March 31, 2009

Re: 15 Boat House Way, Peaks Island – 084 P004 – I-B – deck extension – permit #09-0252

I am in receipt of your application to enlarge your deck at 15 Boat House Way. After reviewing your application, I must deny it because it does not meet the zoning requirements of the I-B zone.

15 Boat House Way  
Exterior Deck

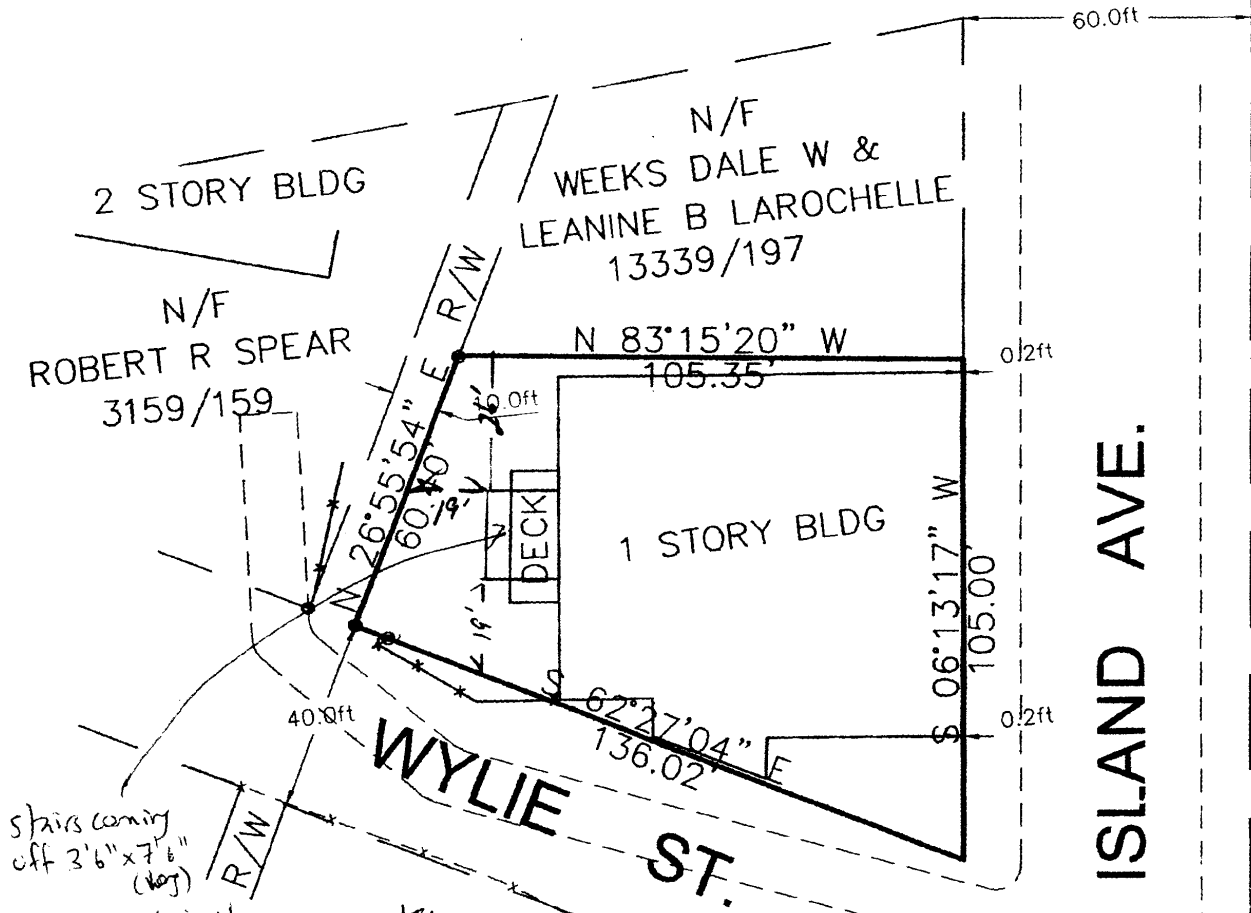
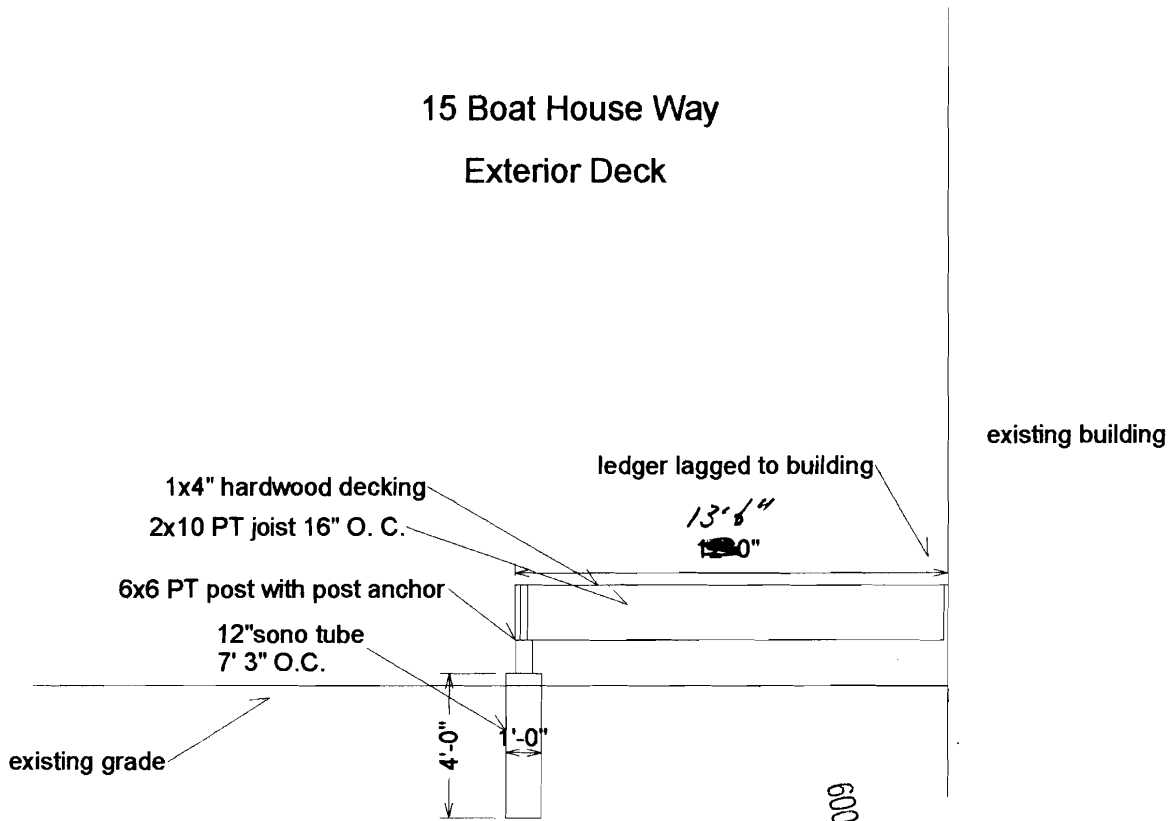
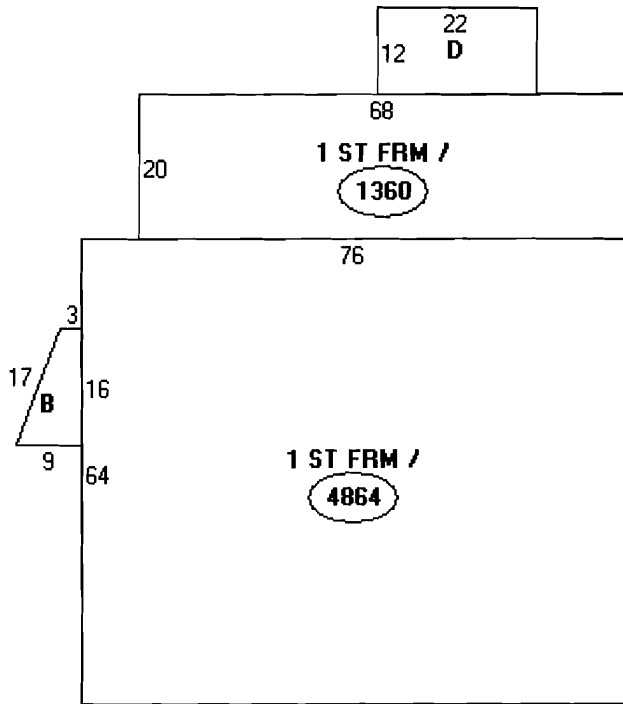
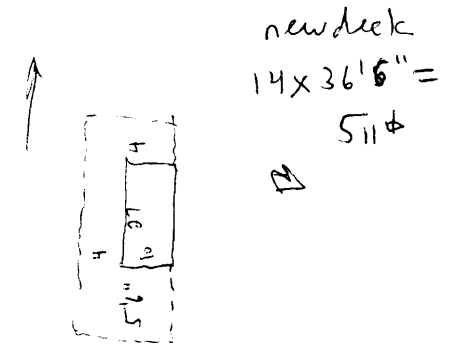
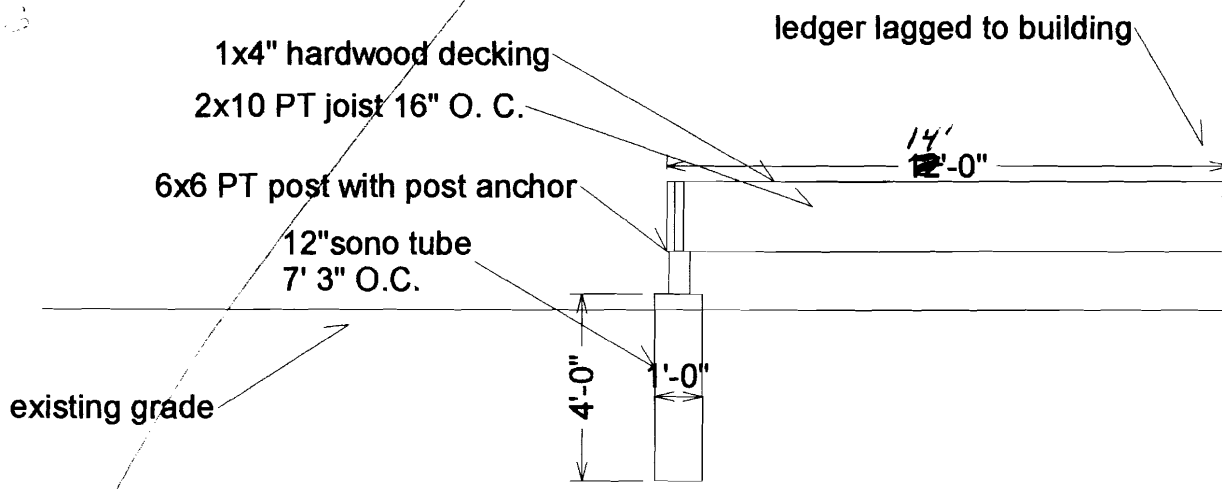
Section 14-226(d) of the ordinance gives the maximum allowable lot coverage as 50% of the lot. The lot is 10,096 square feet, so the footprint of the structure can cover 5048 square feet. The footprint of the existing structure with the 10' x 27' deck is 6574 square feet which is already over the maximum allowable lot coverage. The proposed enlarged deck would add 241 square feet for a total of 6815 square feet of lot coverage. The existing structure and deck are legally nonconforming, but you cannot make the property more nonconforming by enlarging the deck.
